From: TONY PHEBEY [REDACTED]
Sent: 26 November 2019 09:22
To: Zac Denton <Zac.Denton@arun.gov.uk>
Cc: 'Wayne Newton' [REDACTED]
Subject: RE: EP/129/19/HH - Extension of Time

This email is regarding the proposed development at 15 Warren Crescent, East Preston. My Team Leader will be unable to review the proposal until the 20th of November, if you are able to agree an Extension of Time until this date, it would be appreciated.

1422/P02

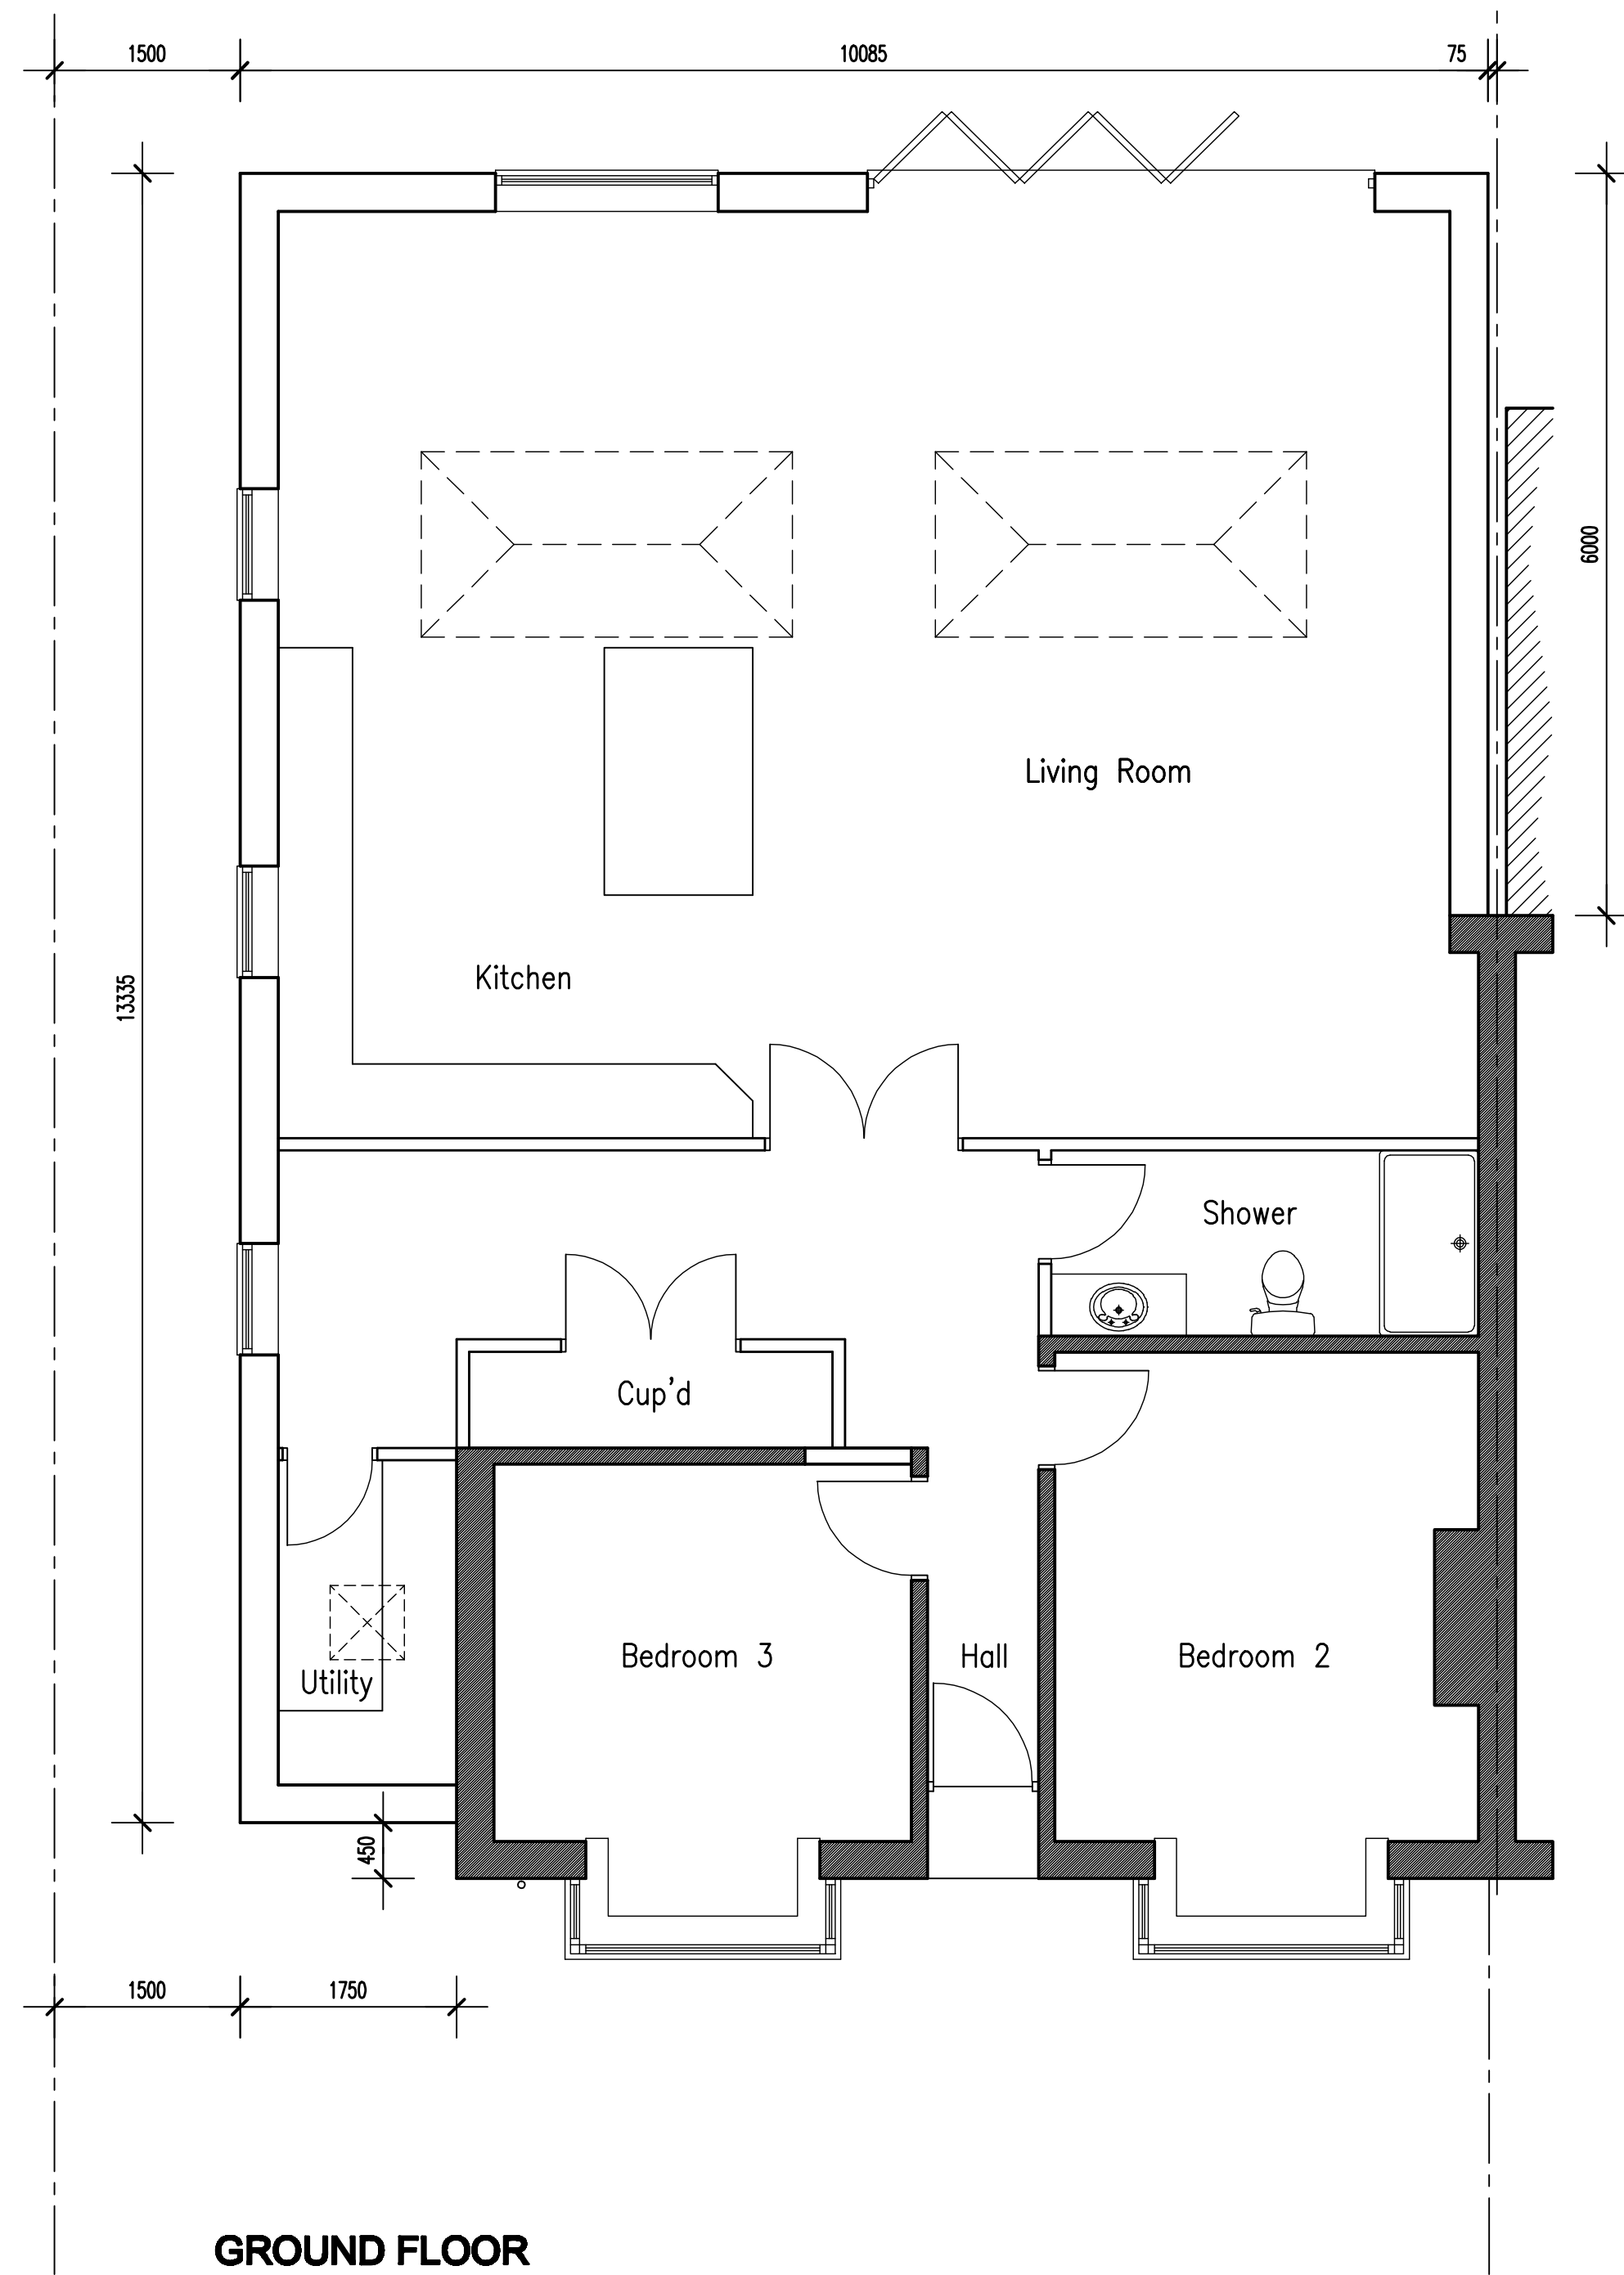
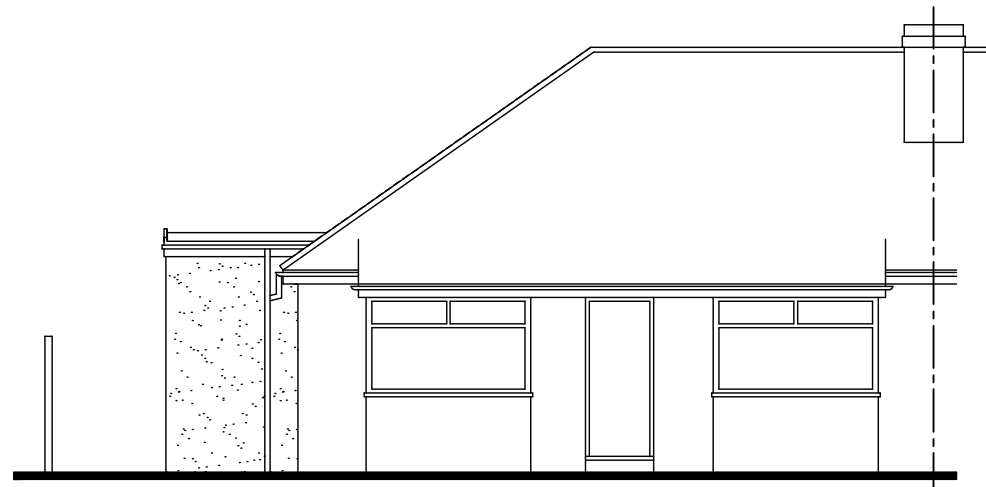
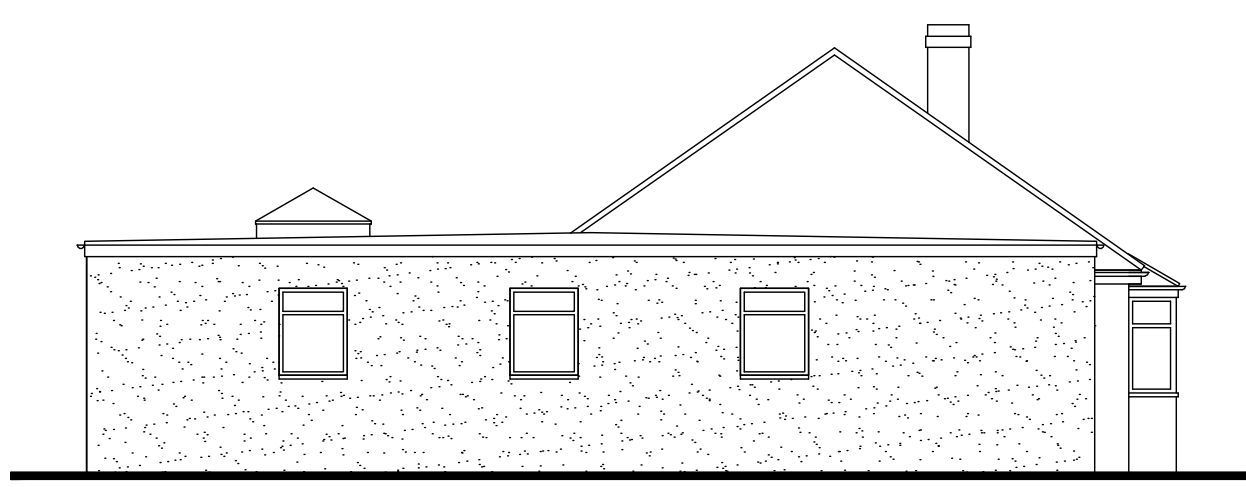
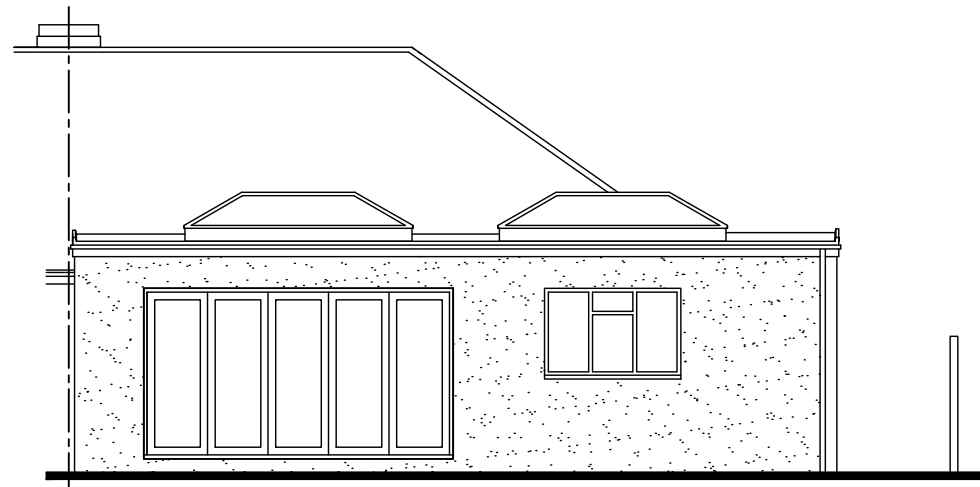
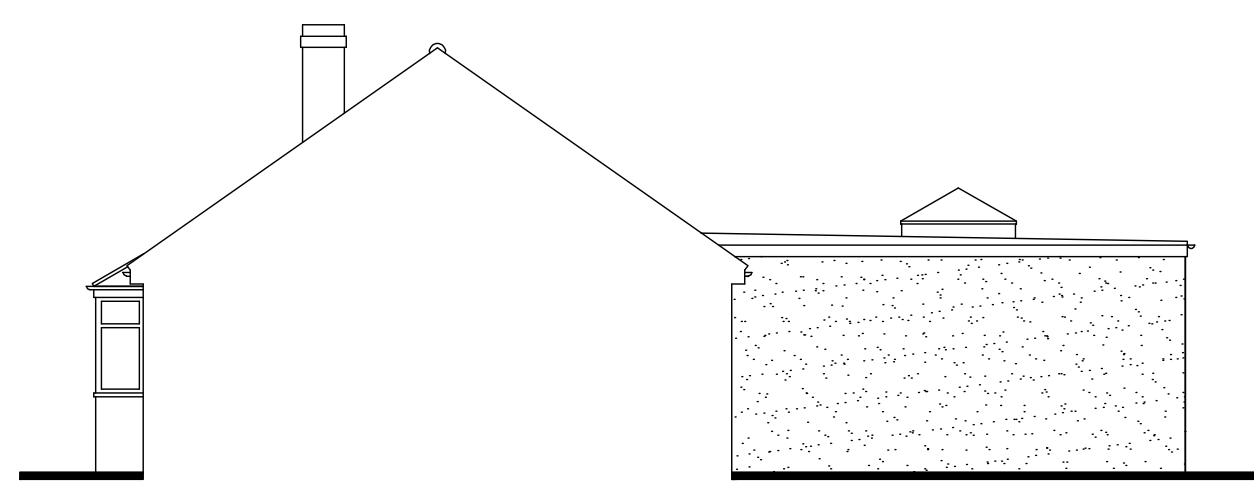
Unfortunately, the 0.5m reduction is not acceptable, if you are able to amend the drawings to be more inline with my previous comments, then this would be appreciated. Alternatively, if you have any other proposals, I am happy to consider these.

However, it is believed that amendments could be made in order to create a scheme that was looked upon more favourably by the LPA. These would be a 1m reduction in length of the rear extension, and a 2.5m reduction of the side element of the extension, away from the street scene.

We have reduced the rear extension by 1 metre as requested however we have reduced the side extension by 0.5 metre in order to maintain the internal utility room. This setback provides a distance of 950mm from the existing frontage which is sufficient to make the new extension appear to be subordinate to the existing bungalow.
